From: [REDACTED]
To: [Aquind Interconnector](#)
Subject: Response to invitation for comments to Third Information Request
Date: 15 December 2021 17:04:46

Application for Development Consent by AQUIND Limited (“the Applicant”) for an Order granting Development Consent for the proposed AQUIND Interconnector (“the AQUIND Interconnector project”)

The following is the response of East Hampshire District Council and Havant Borough Council to the invitation to Interested Parties for comments in response to the ‘Applicant’s Response to Third Information Request’. The comments are restricted to two aspects of the Response; the consideration of alternatives and the micro-siting of the Converter Station.

Plate 3.8 - Converter Station Parameter Plans (two options, Option B(i) Blue dash and Option B(ii) Green dash)

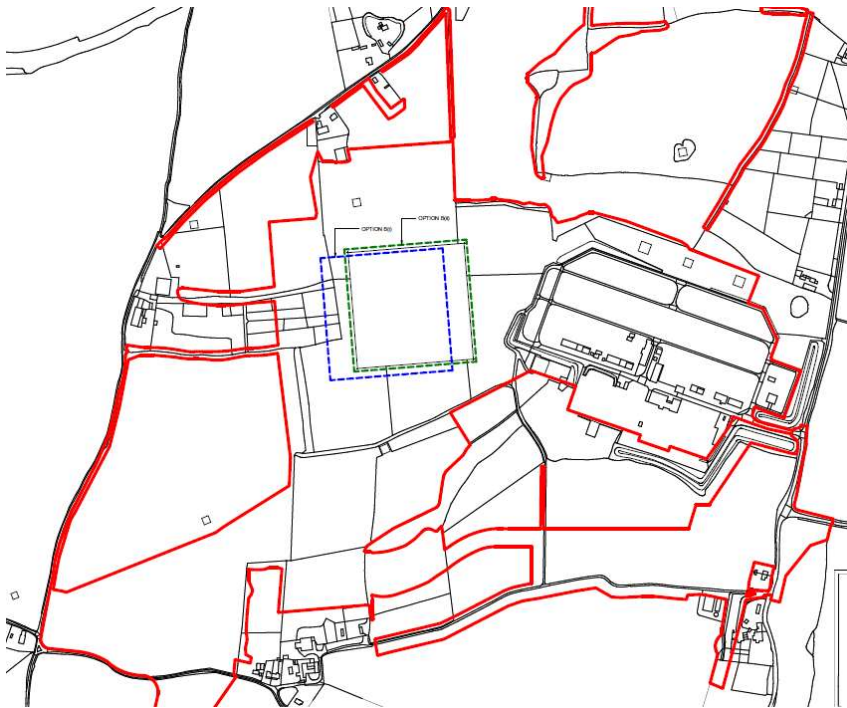
It is noted that at paragraph 5.2 of the Applicant’s Response and the subsequent letter of 6 December 2021 confirming that the land agreements have now been entered into, “we confirm that the Applicant is able to commit to the Converter Station being located in the Option b(ii) location. With that being the case, it is confirmed that the Applicant has no objection to the Secretary of State making an Order which removes the Option b(i) location and provides for the Converter Station to be located in the Option b(ii) location.”

This is welcomed since Option b(ii) is regarded as more suitable and resulting in lesser environmental harm than Option b(i). The amendments summarised at 5.4.1-5.4.6
